Project #: 1007470

Application #: 14DRB-70372

Project Name: LUNA PLACE

**DRB Comments**

PLAT OF
LOTS A, B & C, BLOCK 4
LUNA PLACE
 (A REPLAT OF LOTS 4 THRU 10, BLOCK 4, LUNA PLACE)

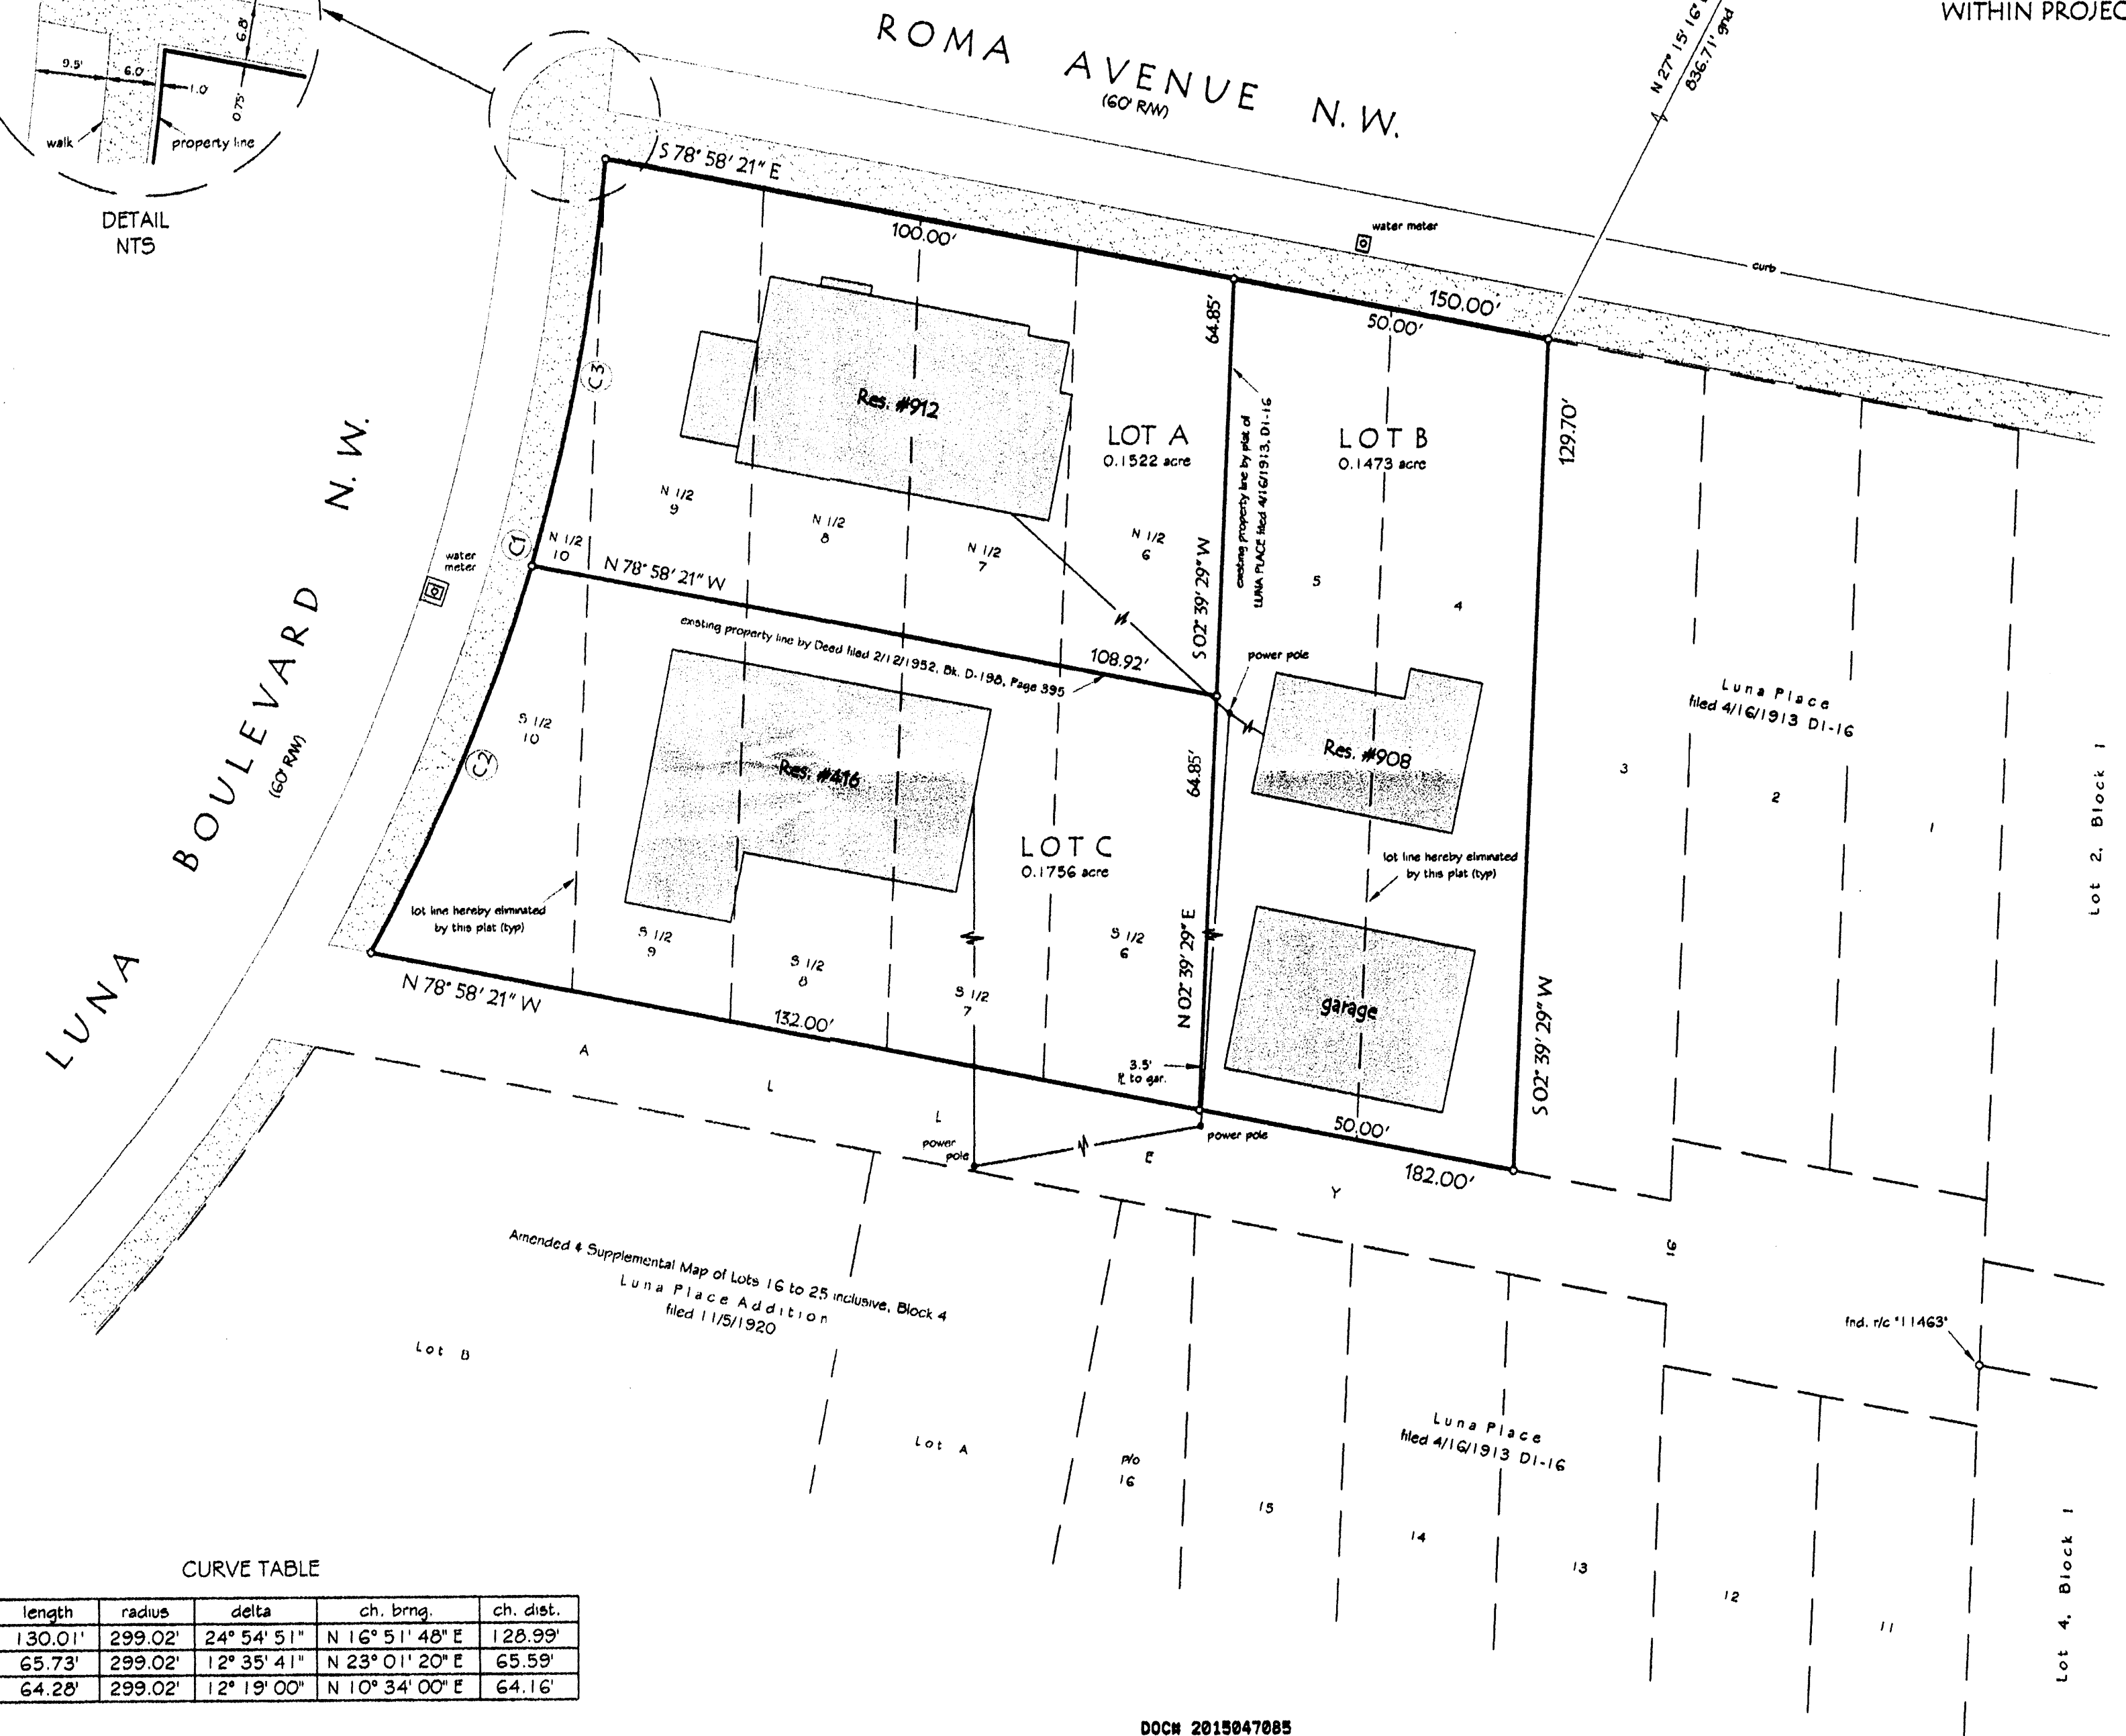
"Portions of" Lots 6-10 must be documented by deed dated prior to 1973.
